**RE: *Green Mountain Falls County Documents Review Comments and Redlines***

ISSUED: 7/17/19
PHOTOMETRIC PLAN
SHEET 10 OF 13

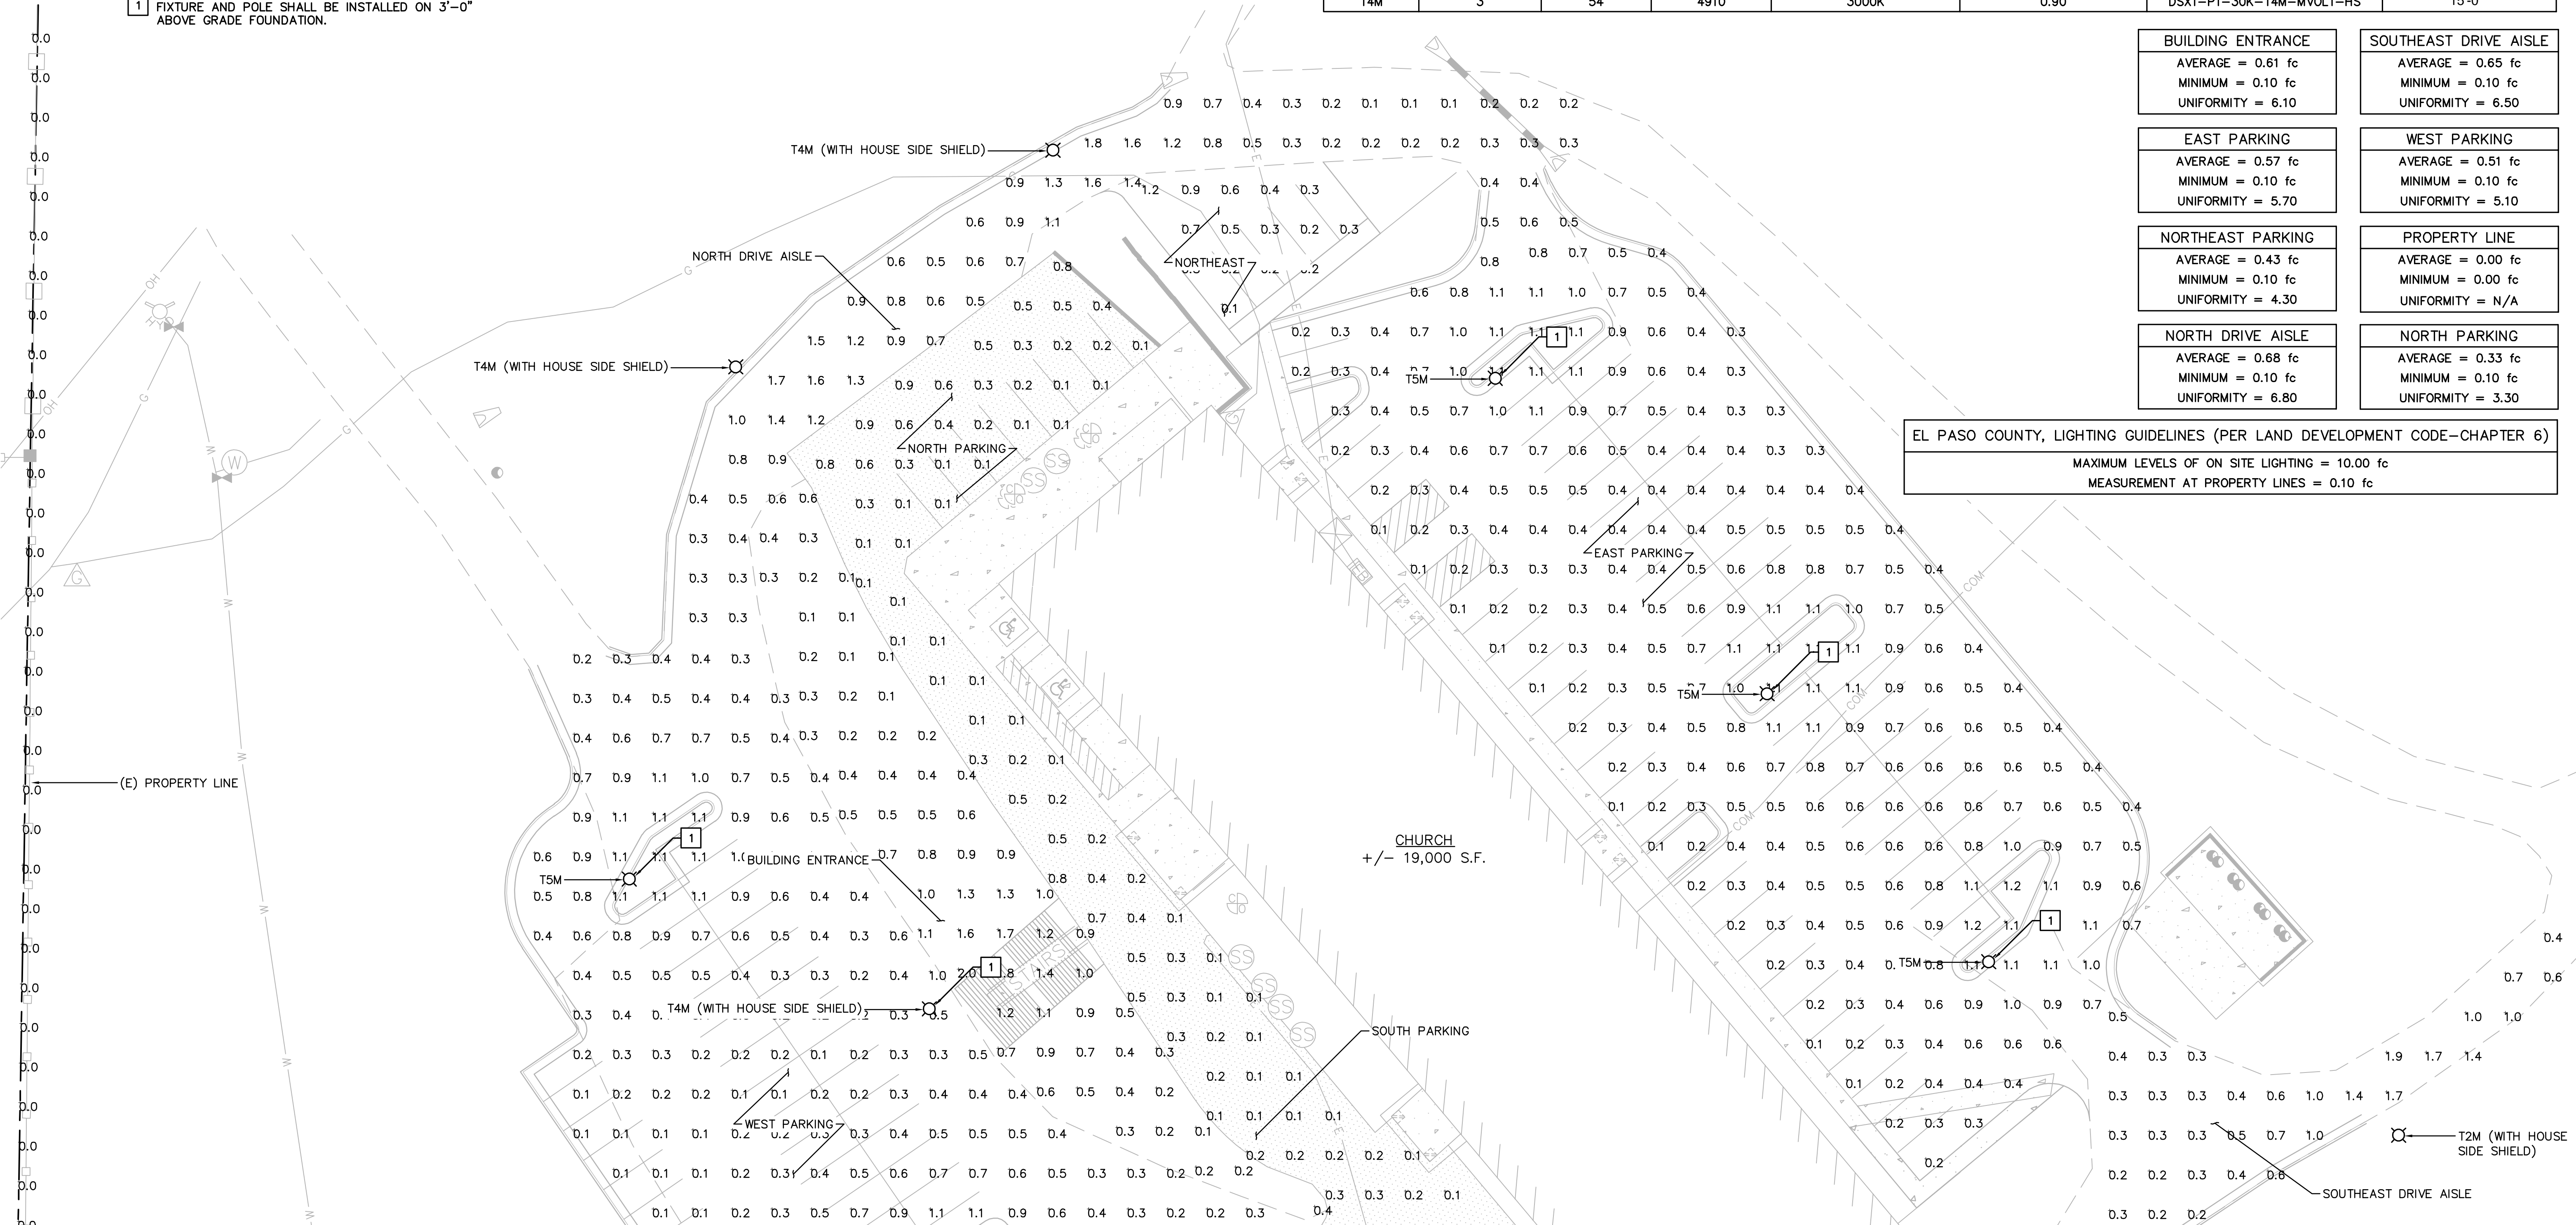
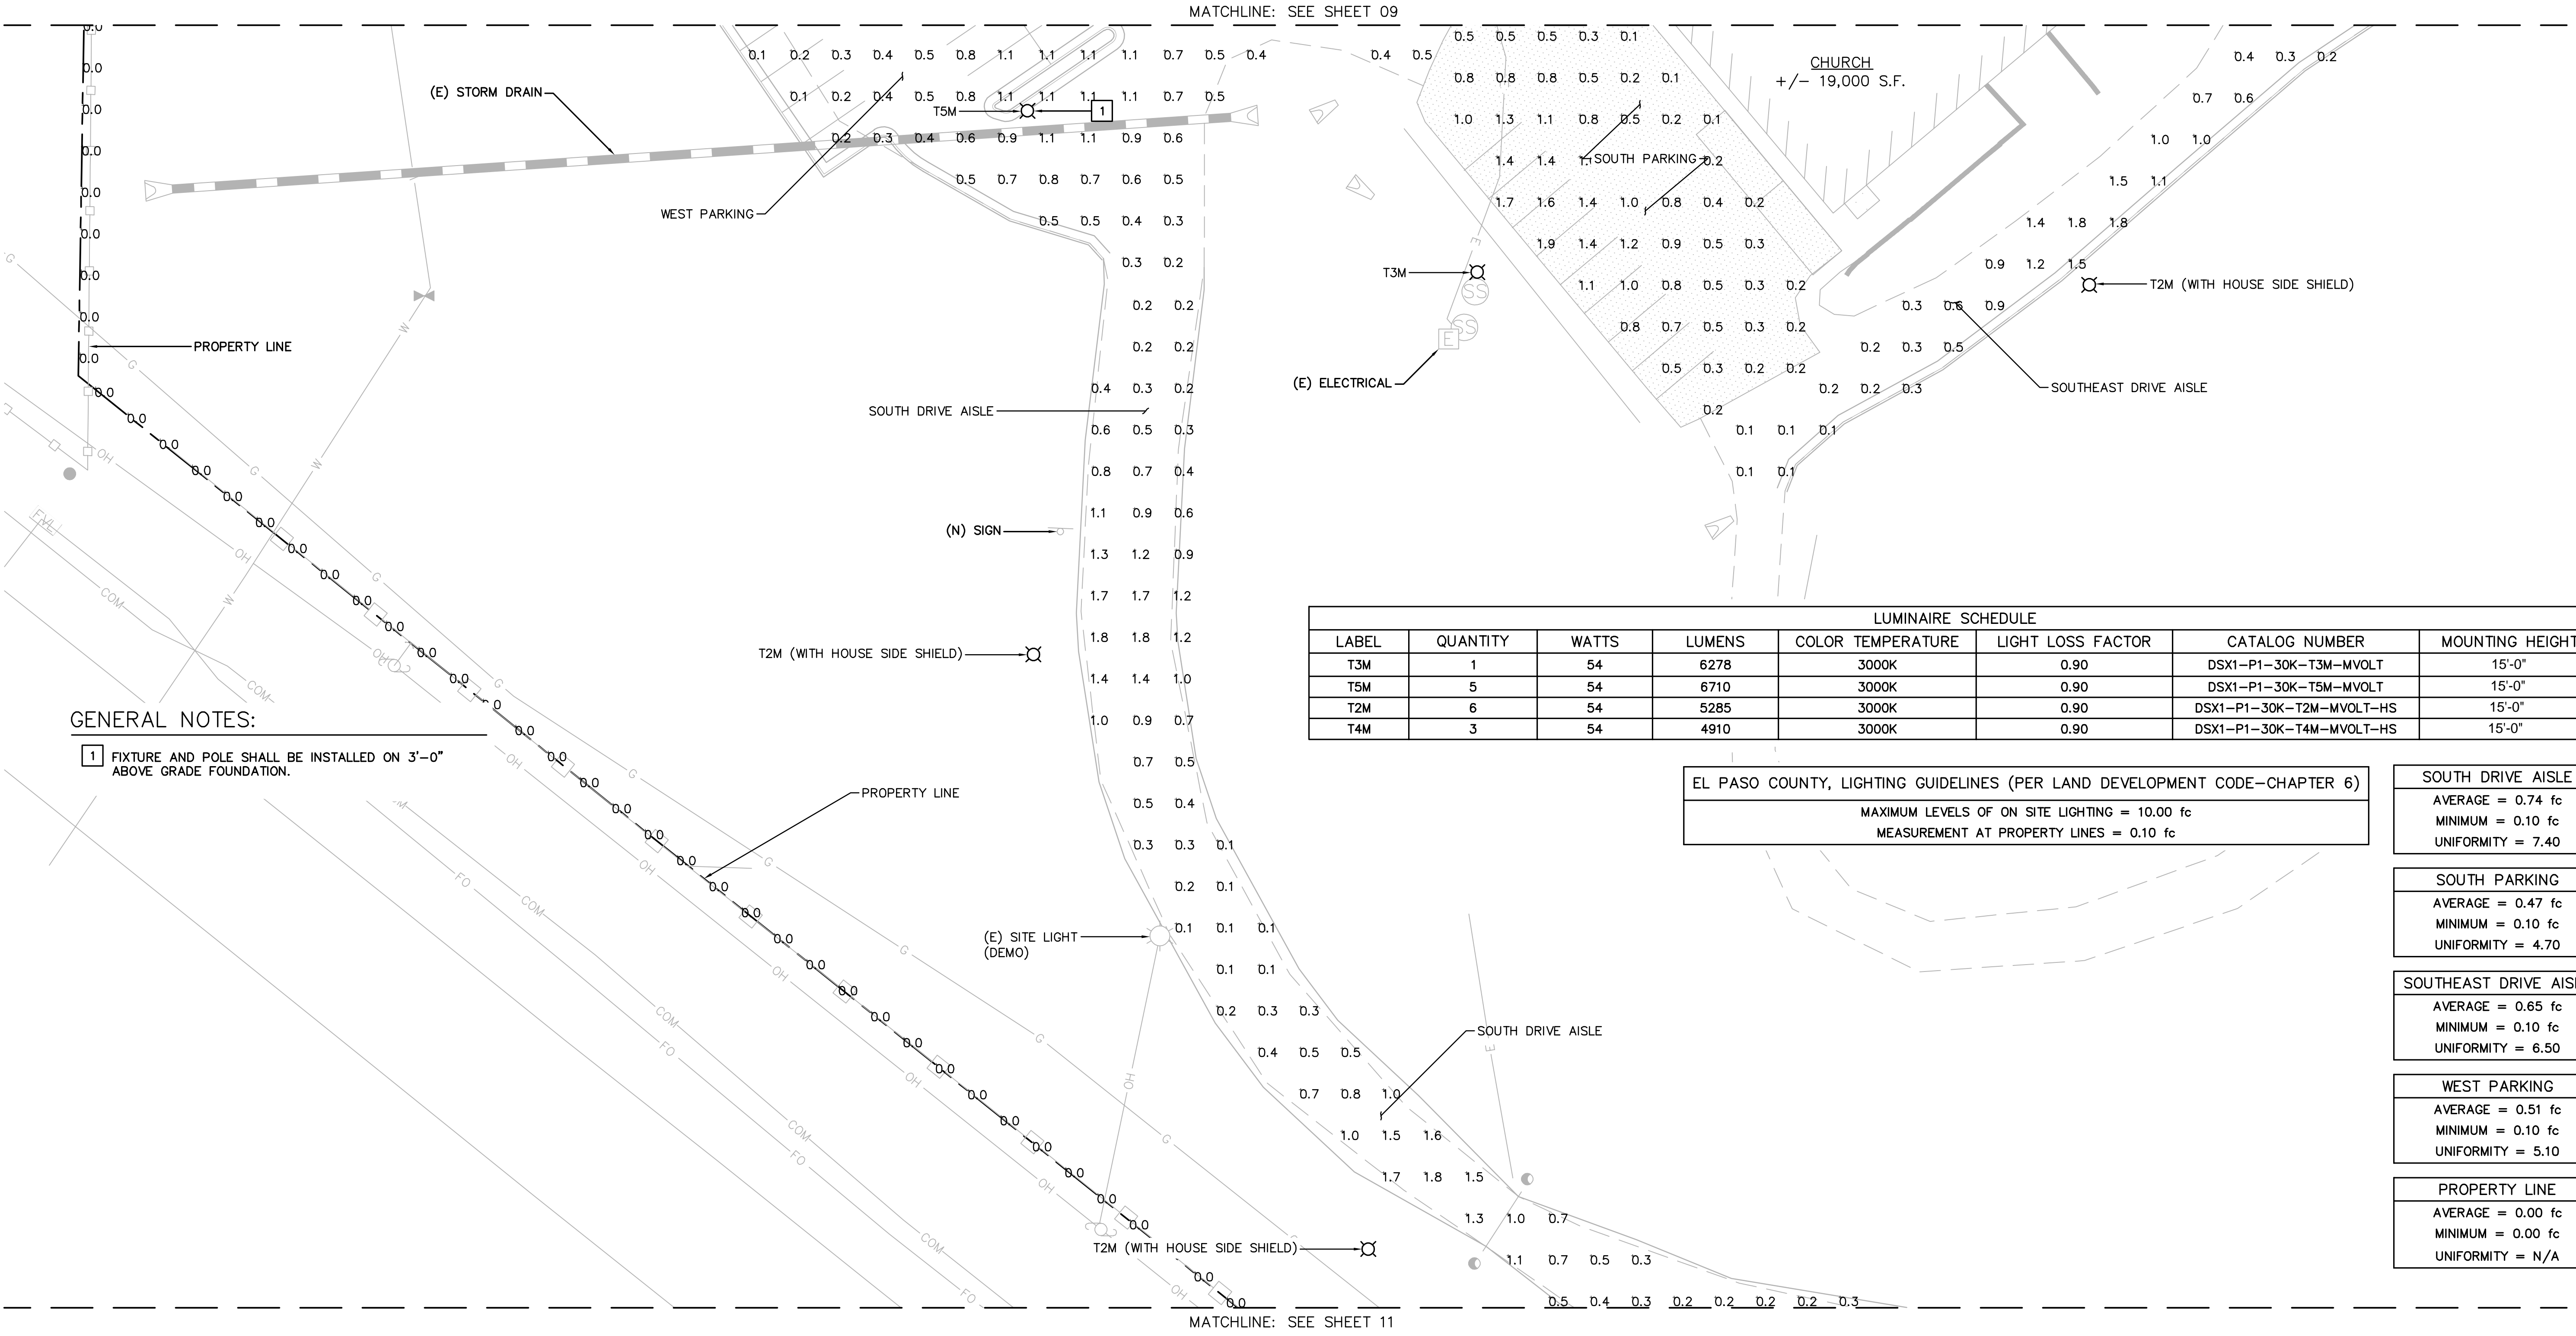
12. Show proposed parking lot pole light fixtures on the landscape plan to alleviate tree/light conflicts.  
*Response: Fixtures are shown on the plans.*
